Tel: 01895 250230
Case Officer: Liz Arnold
Email: larnold@hillington.gov.uk
Date: 17th December 2020
Our Ref: 24650/PRC/2020/210

RE: First floor rear extension and extension to roof to create additional habitable space
SITE: 51 Ickenham Road Ruislip

Proposed Loft Floor Plan
Scale 1:100

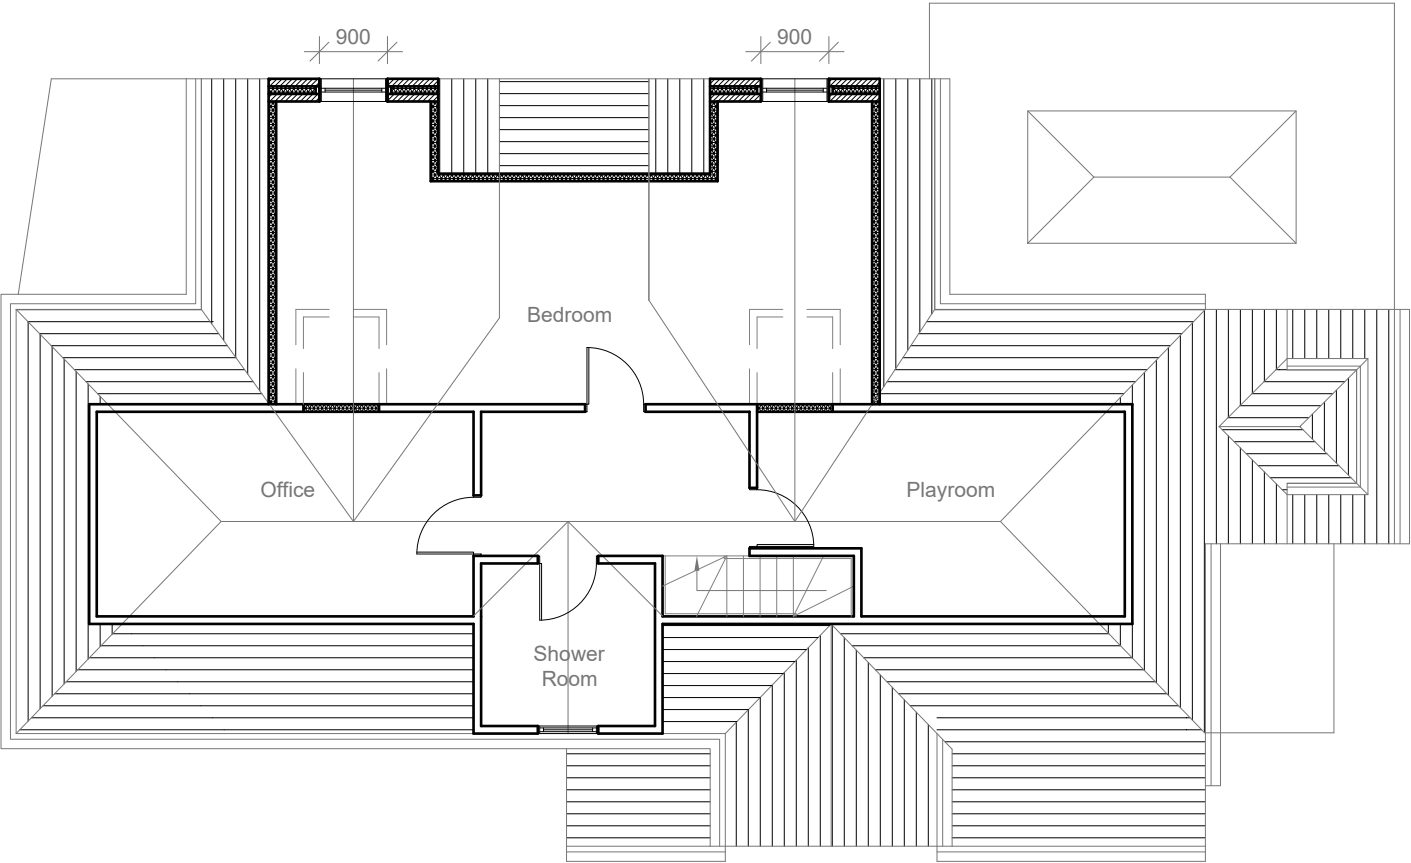
The proposed first floor rear extension measures 9.66m in width and 3.05m in depth. This is set beneath a large crown roof formed between the extended gables which would provide additional accommodation within the roofspace. The Conservation Officer previously raised concerns over a lesser scheme, which was of the same dimensions and set beneath the extended gables, with a smaller crown detail and a sloping roof down to a matching eaves level with the main roof. At appeal the Planning Inspector, whilst noting the Officer's concerns advised that the design proposal would harmonise well with the existing dwelling, and would not be visible within the street scene. It would also respect the existing strong gable features on the rear elevation.

The submitted plans indicate that the proposed first floor extension measures 3 m in depth and is set away from the side boundaries by approximately 3 m to East with no. 49 and 9.5 m

Proposed Rear Elevation
Scale 1:100

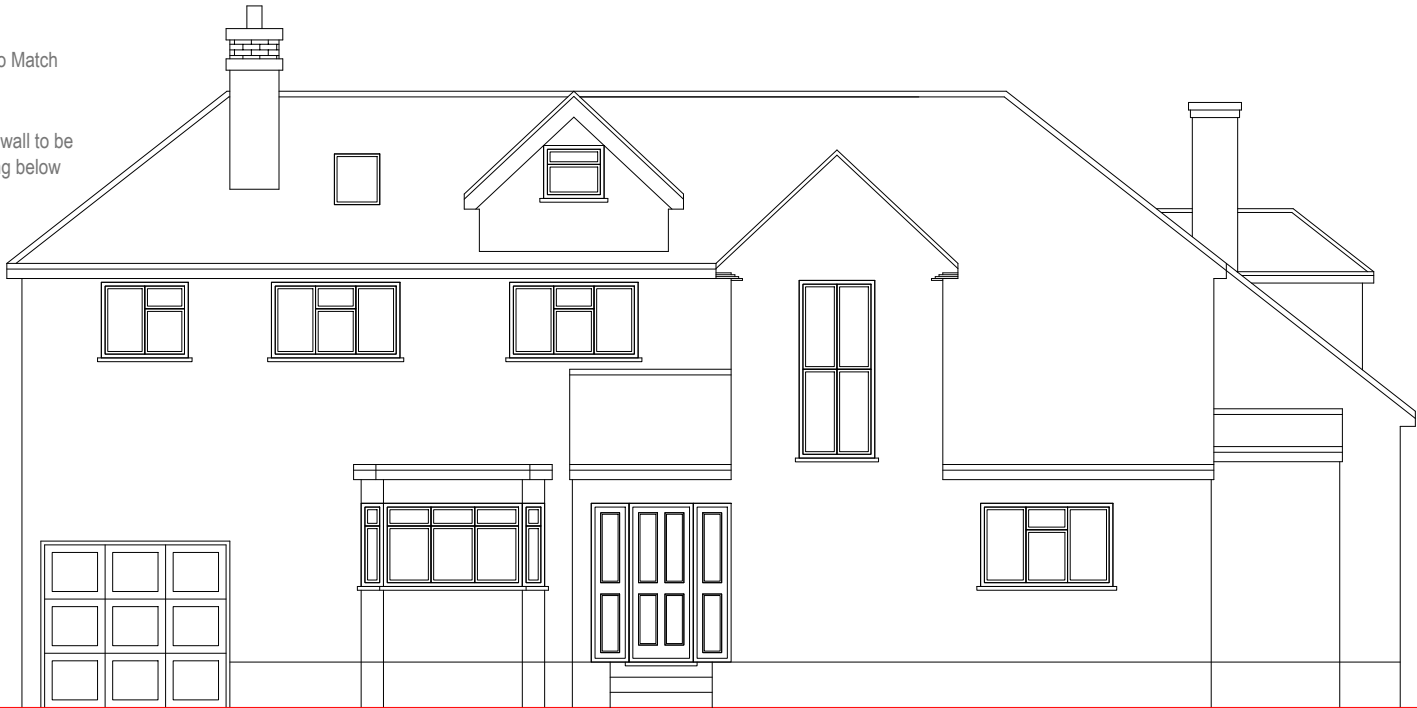
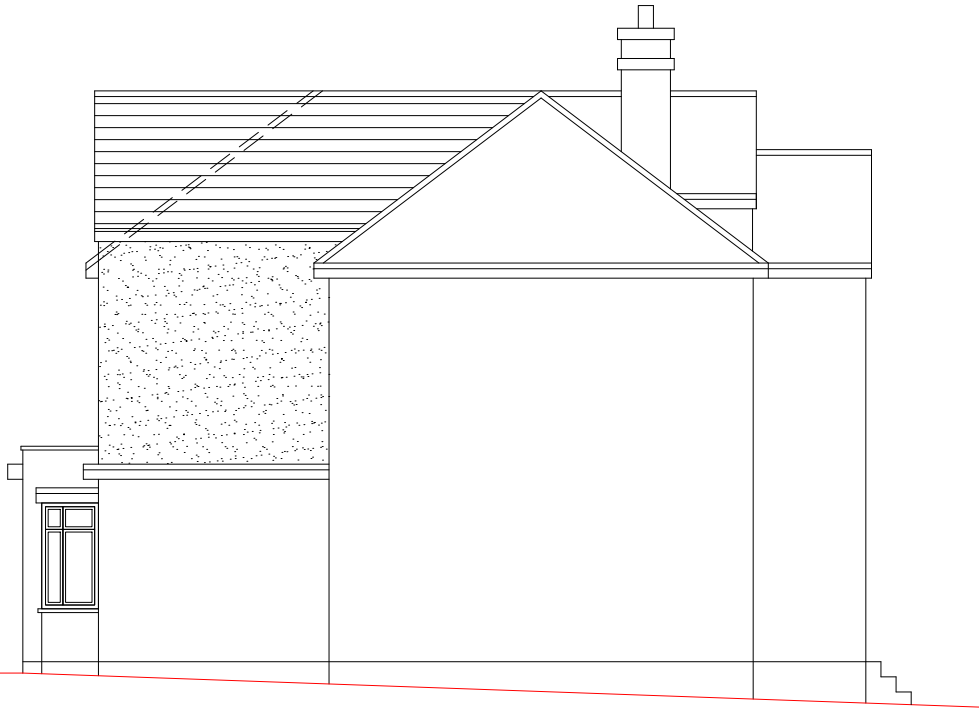
The current submission would completely subsume the existing gables and result in what appears as a large three storey flat roofed extension. The very large characterless facade with the higher eaves level, would fail to appear as a subordinate addition and would be completely out of keeping with the architectural character of the existing property. Although the alterations may be at the rear of the property, conservation areas are not designated as a series of street scenes. Views from private rear gardens form part of how the heritage asset may be experienced. The source of the view does not lessen the requirement to preserve or enhance the conservation area, in accordance with section 72 of the Planning (Listed Building and Conservation Areas) Act 1990. The proposal would result in a substantial addition to the rear of the property, which is inappropriate in its design and bulk, in the context of a building of interest, in this part of the Ruislip Village Conservation Area. Therefore in terms of appearance the proposed extension would fail to respect the character and appearance of the existing property and the wider Conservation Area and is considered unacceptable.
